TfNSW Reference: SYD21/00574/04

DPIE Reference: SSD-18204994

**EXHIBITION OF EIS - EXHIBITION OF EIS - SNACK BRANDS MANUFACTURING
FACILITY - 14 & 2 DISTRIBUTION DRIVE, ORCHARD HILLS**

Attachement A

ENTRY (B-DOUBLES)

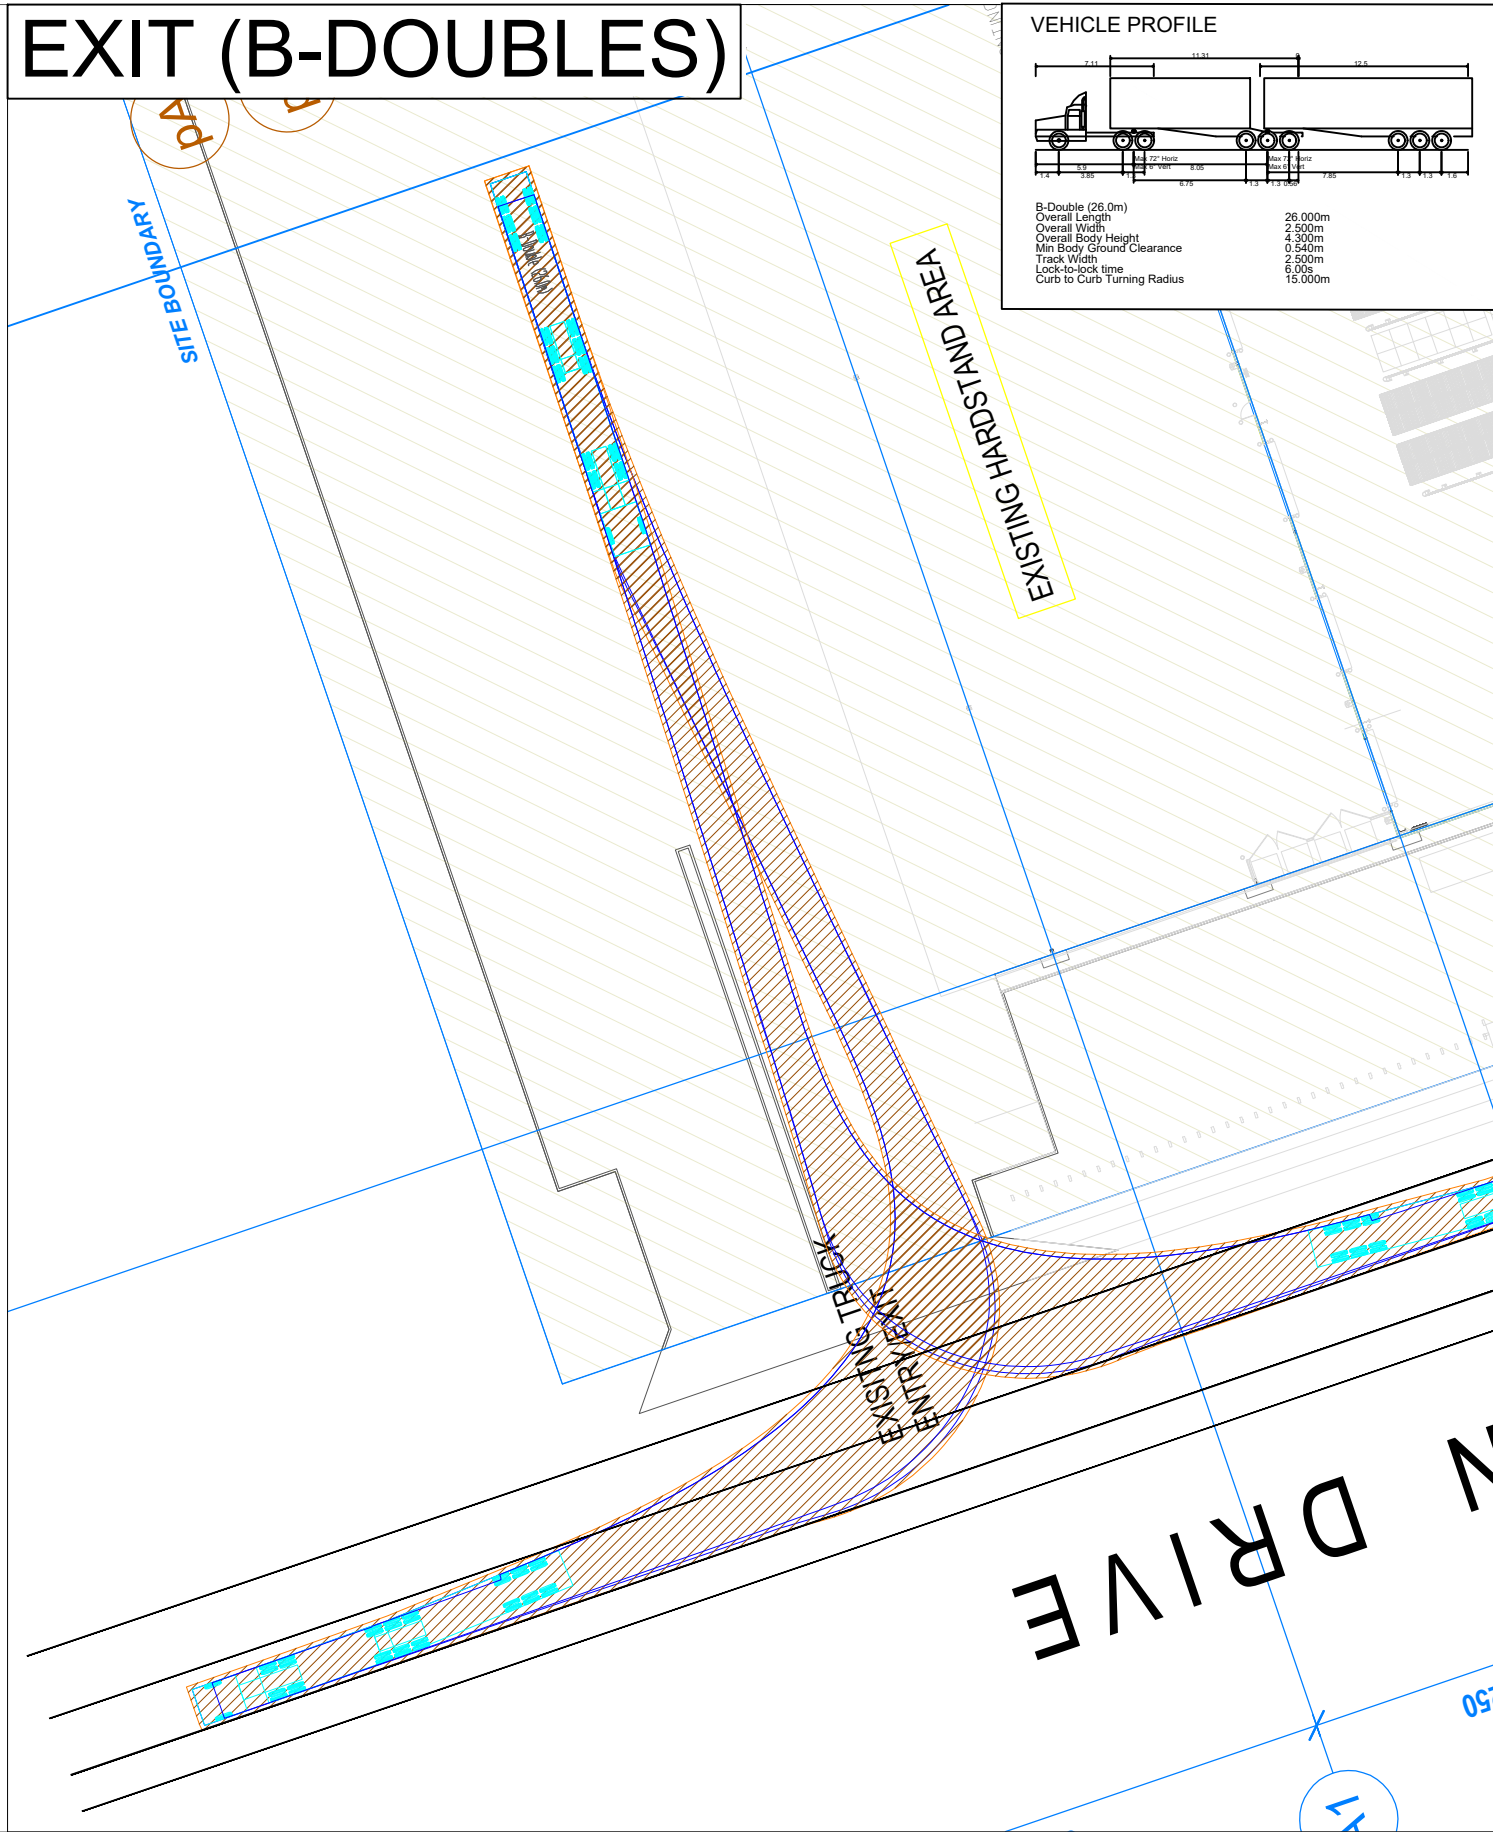
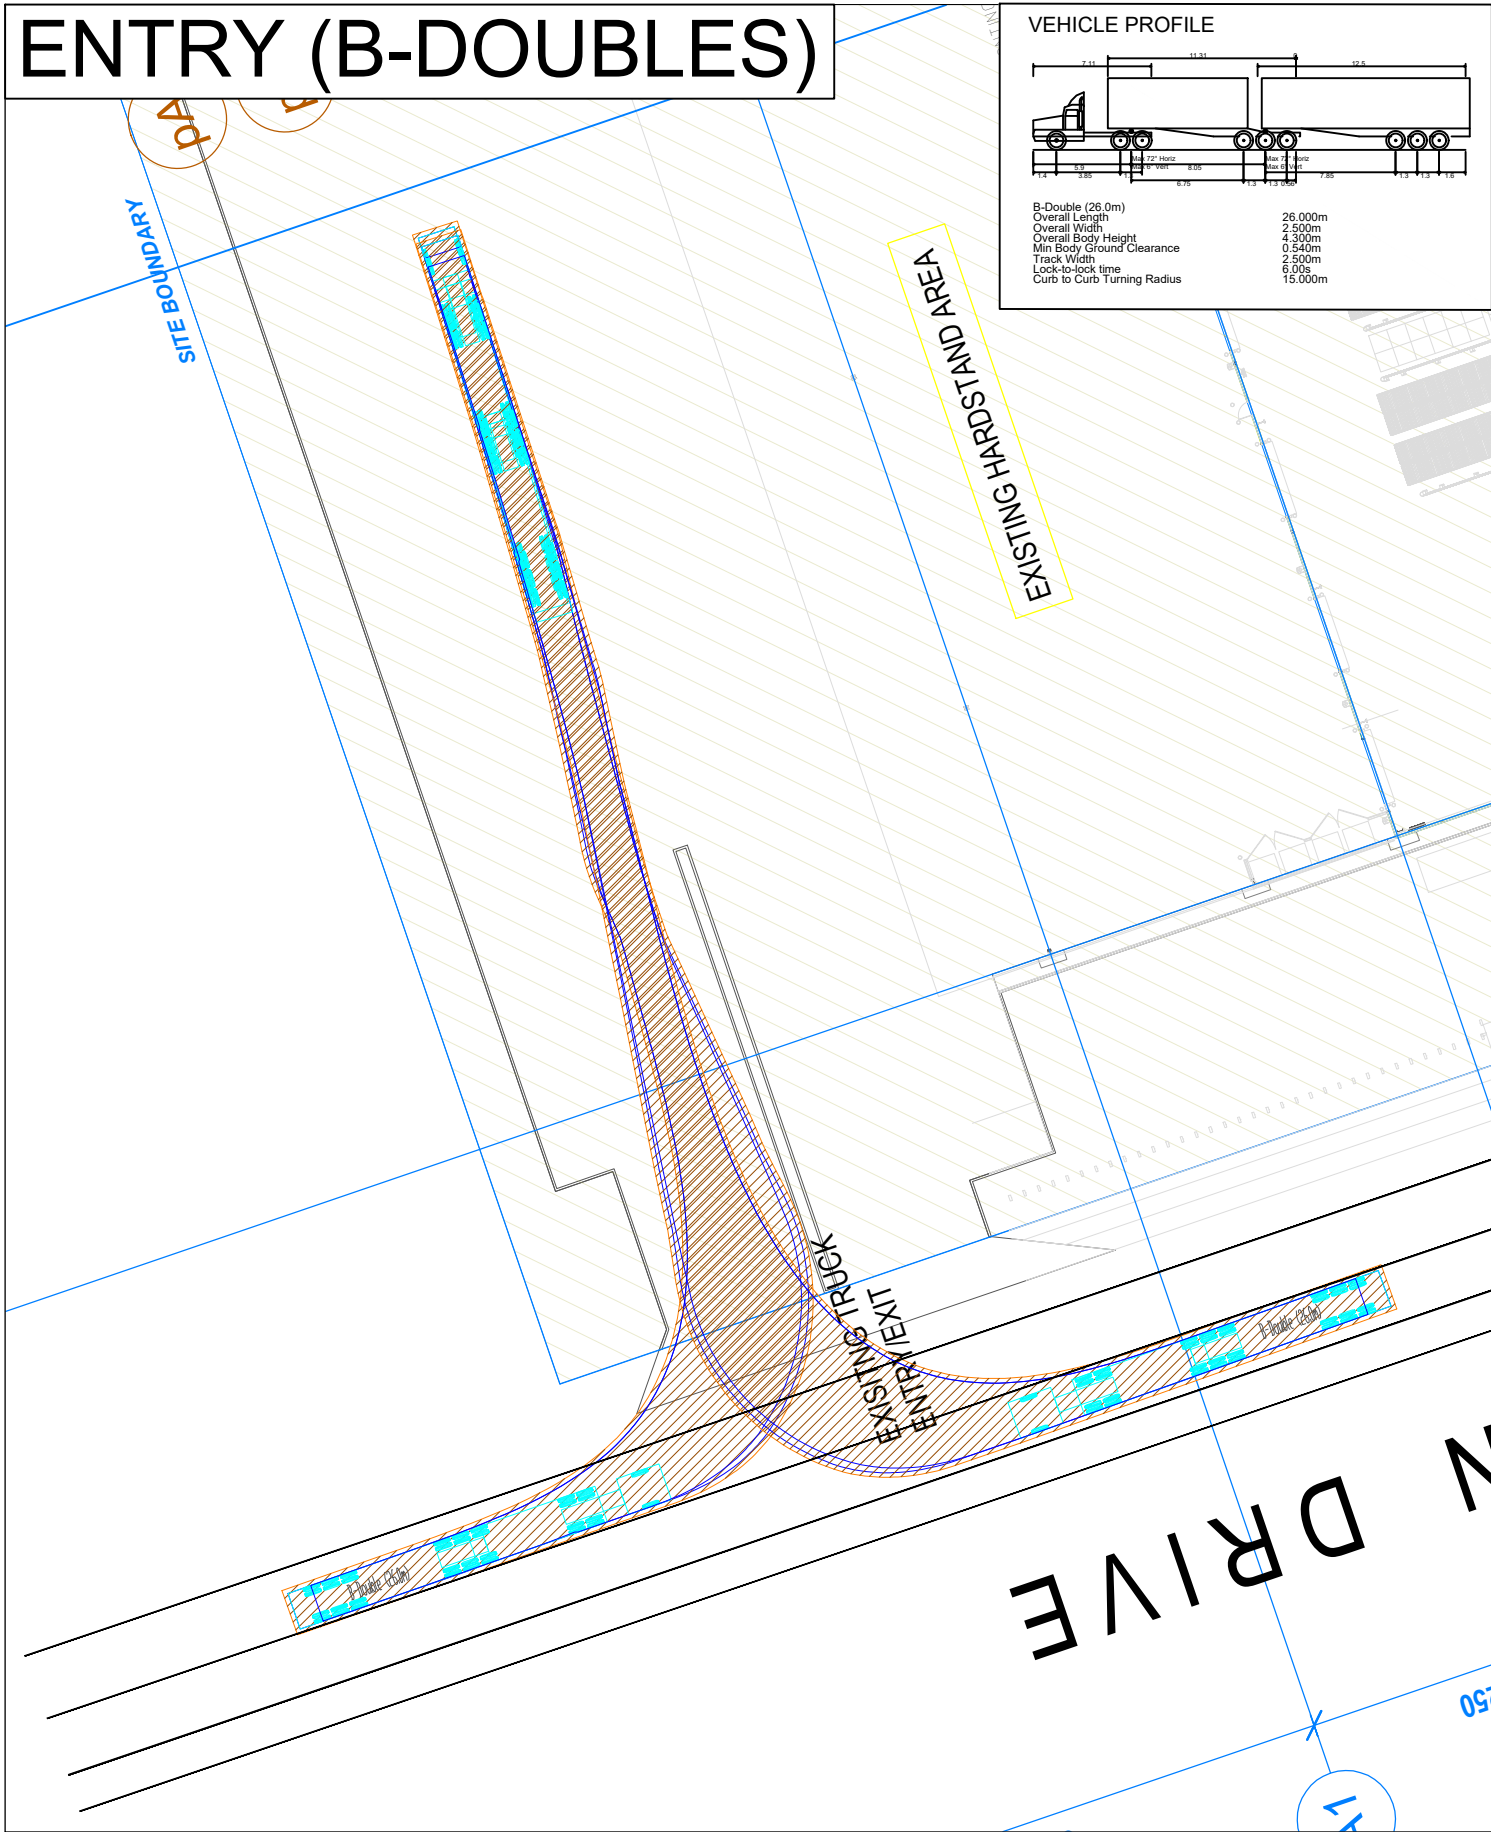
Mamre Road is an approved PBS 2B route and large industrial development within Western Sydney Employment Area should consider PBS 2B as the design vehicle. However, the Transport Assessment (TA) site accesses and internal hardstand areas have been designed to cater for trucks of up to 26.0 metres B-doubles.

The TA needs to graphically demonstrate site accesses and internal hardstand areas have been designed to cater for trucks of up to a 30m PBS Level 2B vehicle.
